Your Reference: MP10_0171
Our Reference: NCA/23/2010
Contact: David Little
Telephone: 9806 5481
Fax: 9806 5901

4 October 2011

**Major Project 10_0171 (330 Church Street, Parramatta)
Mixed use residential, retail and commercial development**

01 PLAN - PARKING LEVEL 04
1:200 @ A1

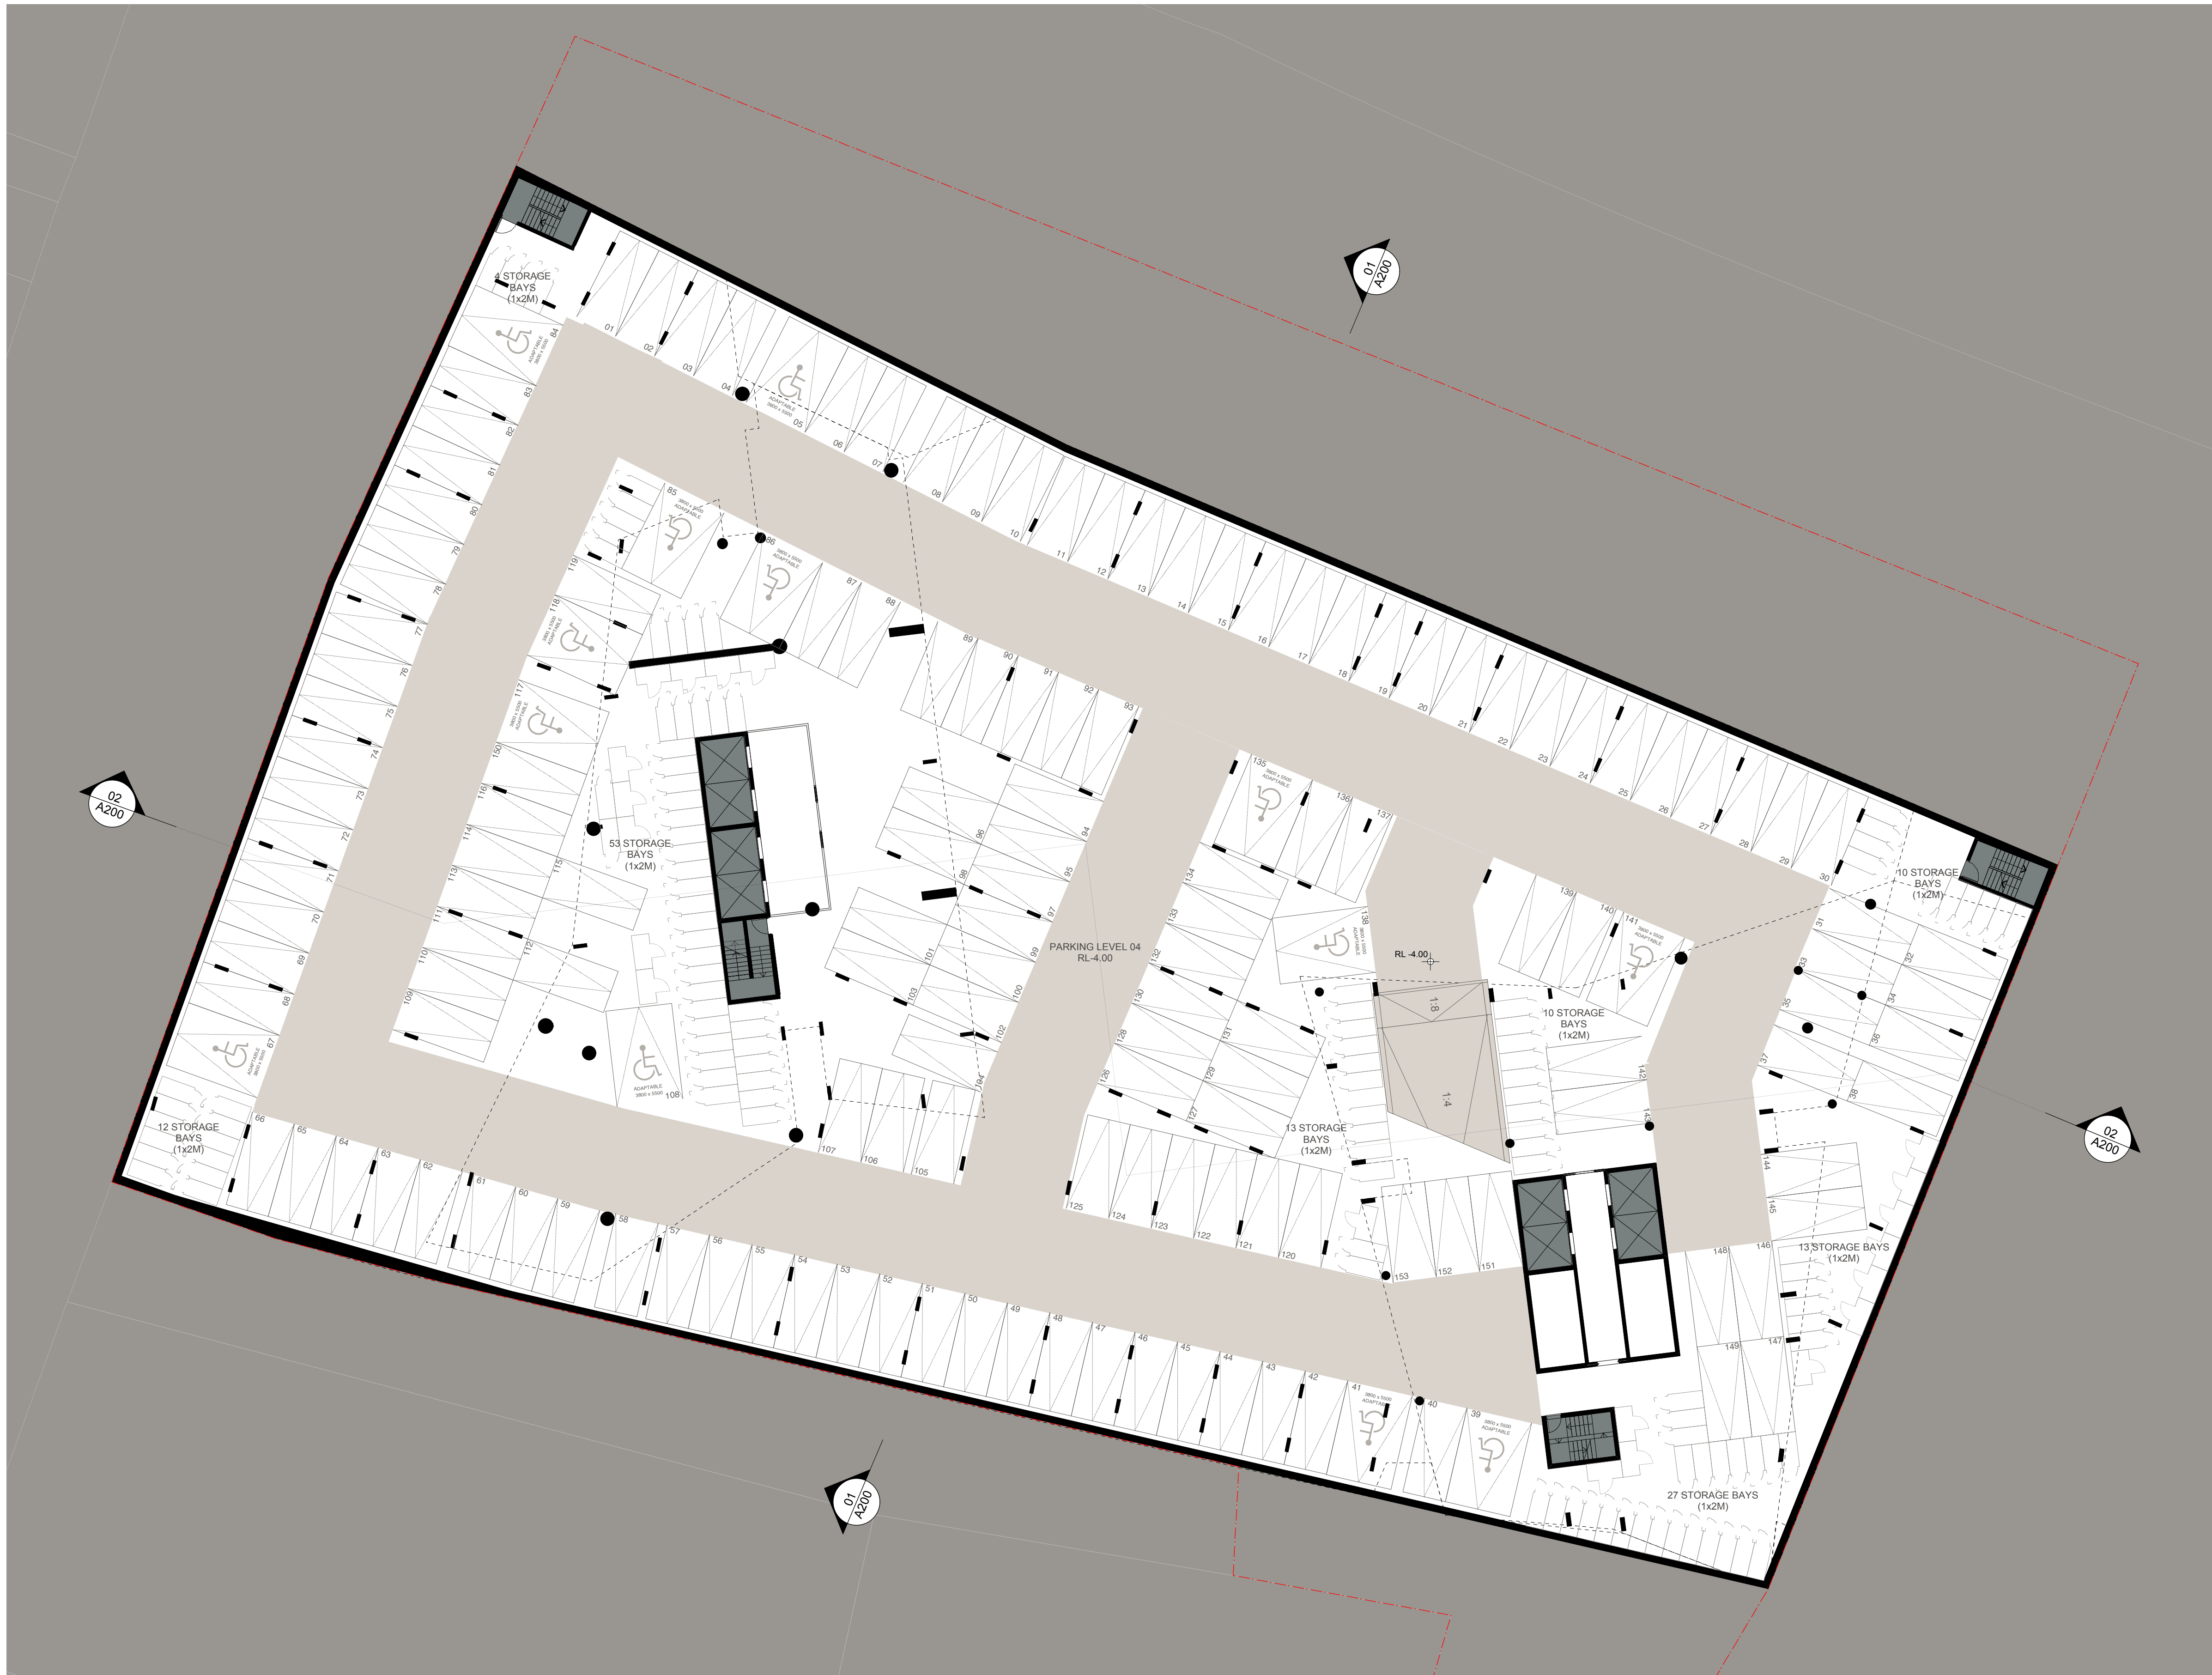
The dimensions and configuration of the disabled parking spaces in basement levels 2 – 4, as shown on the plans do not comply with AS 2890.6-2009 and should be amended to comply with the Australian Standard. It is noted that dimensions and configuration of "adaptable spaces" should be the same as "disabled parking spaces" in accordance with AS 2890.6-2009.

The other stacked parking spaces provided on basement levels 2-4 are to be marked for residential spaces and each parking space should be used by the same tenants/owners only.

It is also recommended that the traffic movements on basement level parking areas should be marked on the pavement by directional arrows.

- The dimensions and configuration of “disabled parking spaces” and “adaptable spaces” must be in accordance with AS 2890.6-2009.
- The stacked parking spaces (91-98, 124 -128 and 131-132) are to be marked for the shopkeepers/owners only.

- The other stacked parking spaces provided on the basement levels 2-4 are to be marked for residential spaces and each parking space should be used by the same tenants/owners only.

- The traffic movements on basement level parking areas should be marked on the pavement by directional arrows.
- The Part 3A flood submission should consist of a detailed flood impact assessment which includes the abovementioned requirements under the heading “Catchment Management”. Any amendments to the proposed development should reflect the findings and recommendations of the assessment.

01 PLAN - PARKING LEVEL 01
1:200 @ A1

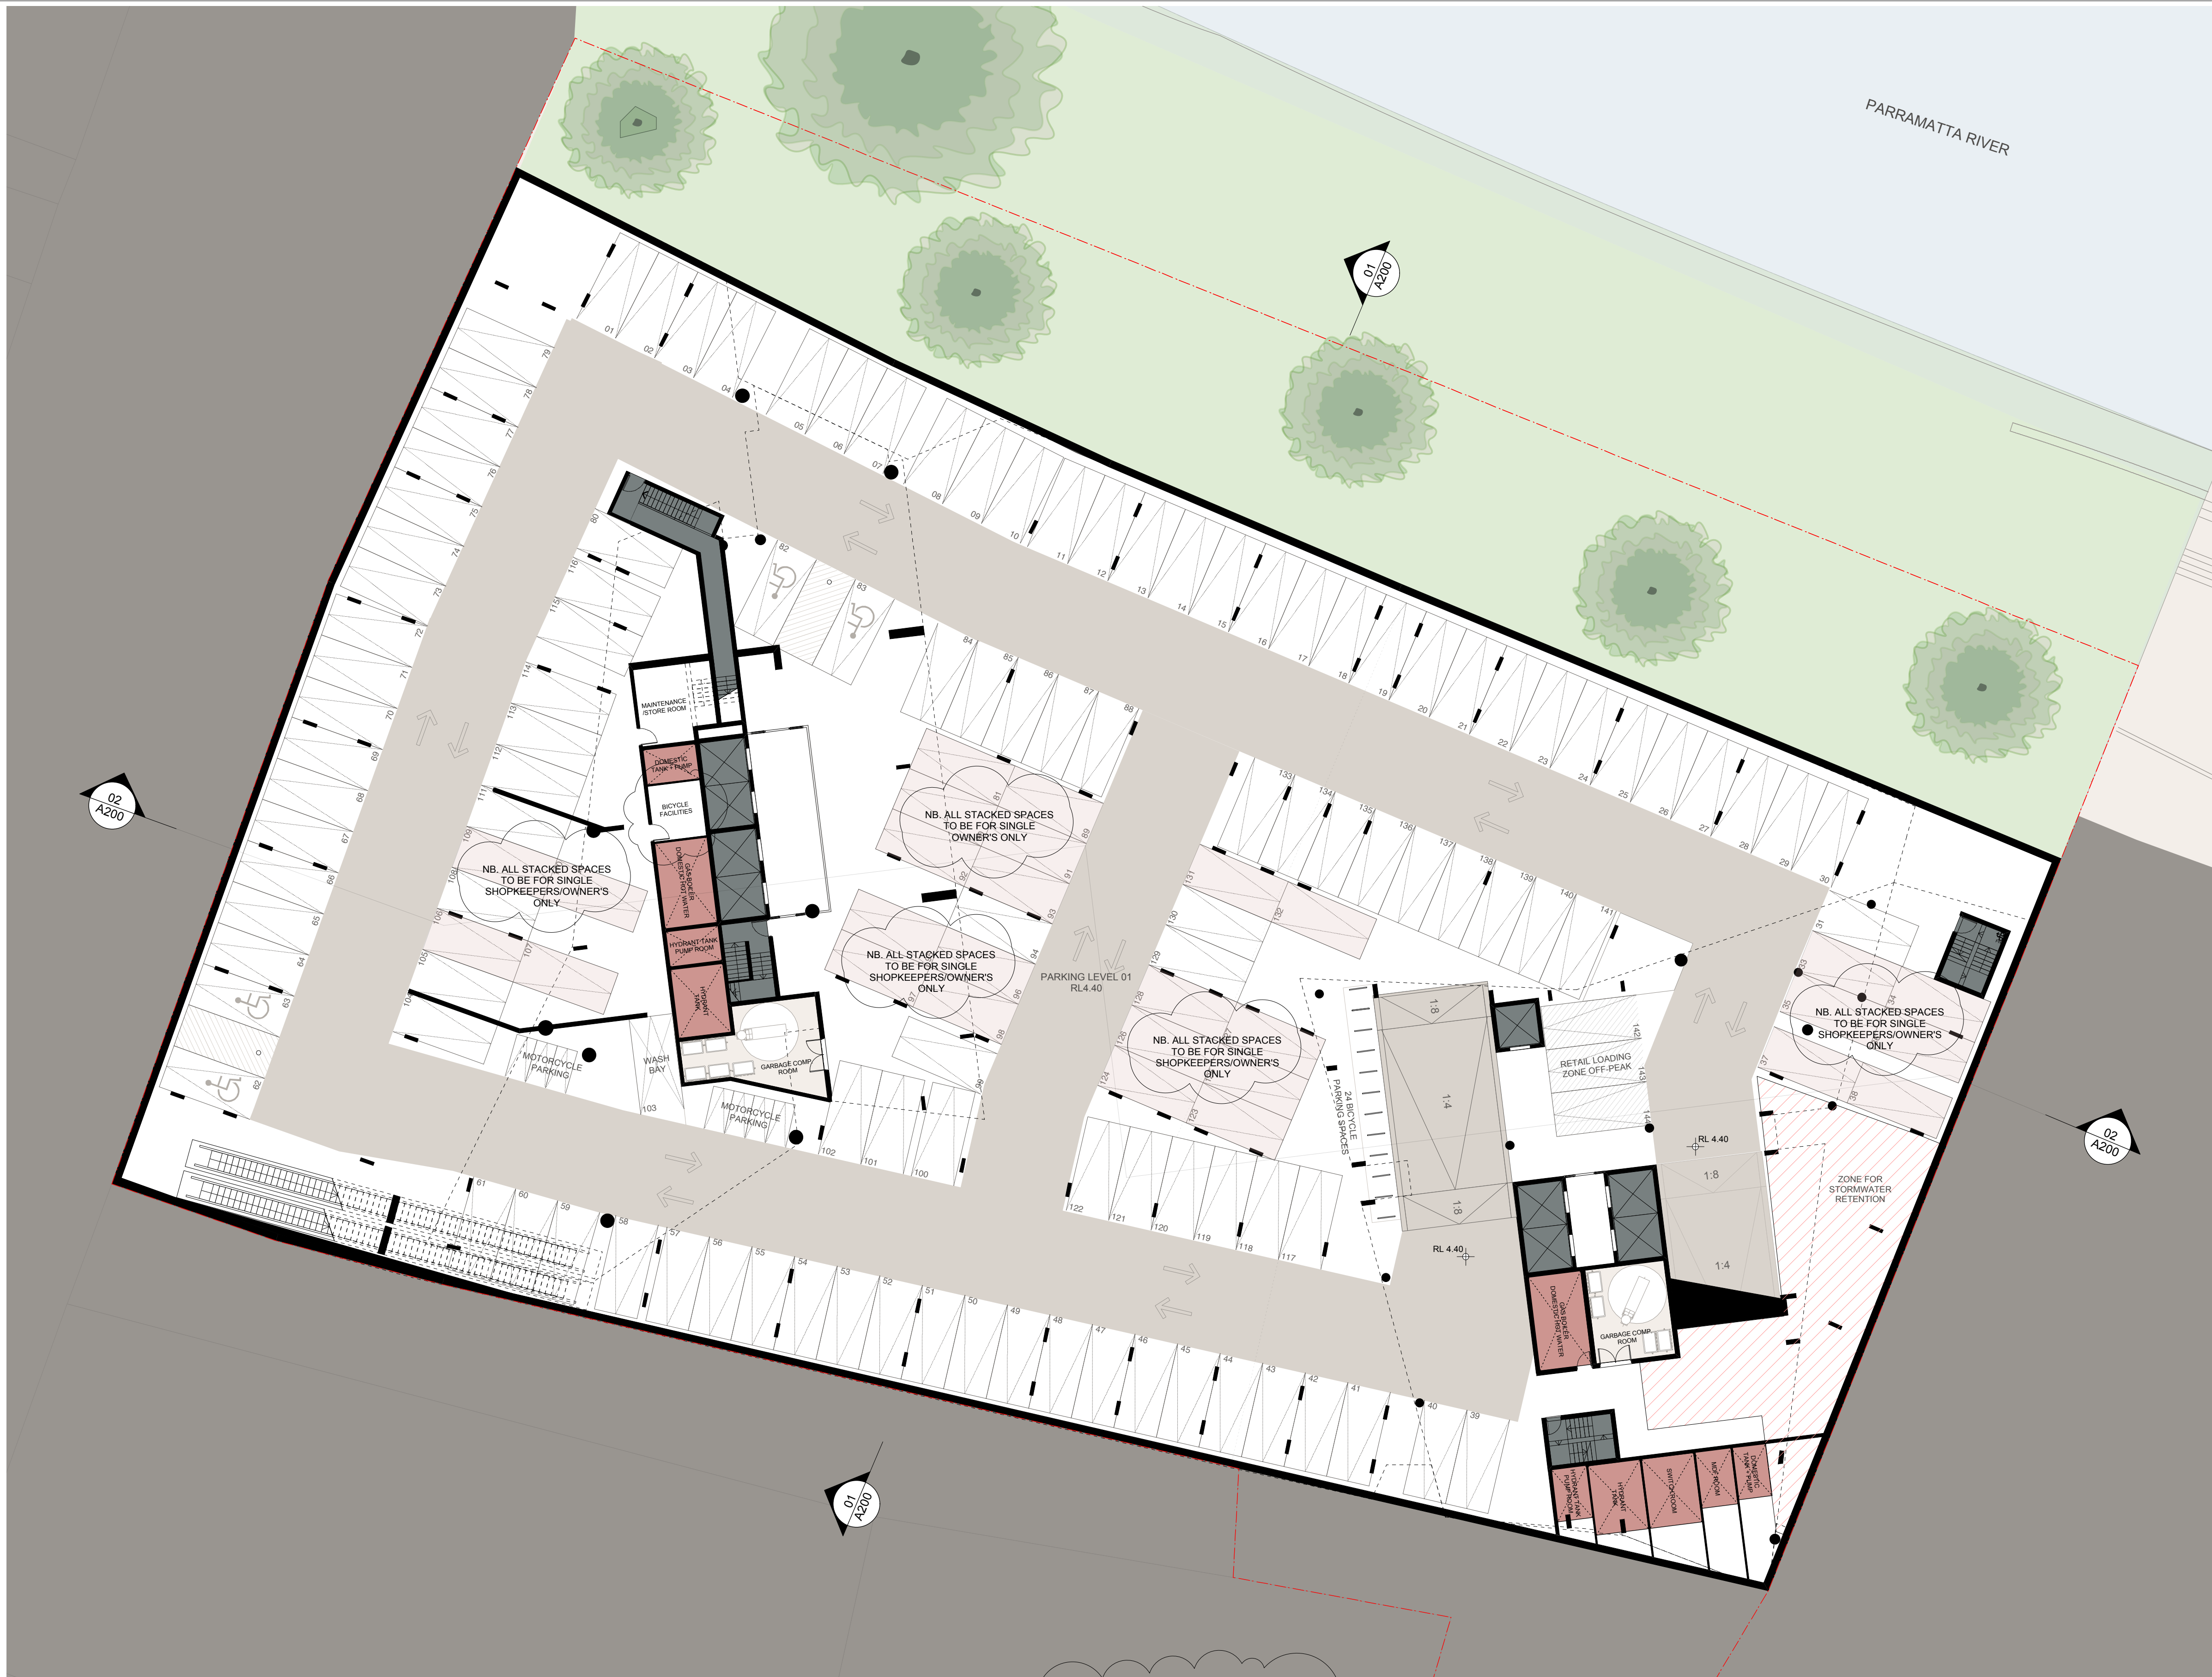
It is understood that the parking spaces provided on basement level 1 will be used by the retail development. It is recommended that the stacked parking spaces (91-98, 124 -128 and 131-132) be marked for the shopkeepers/owners only.
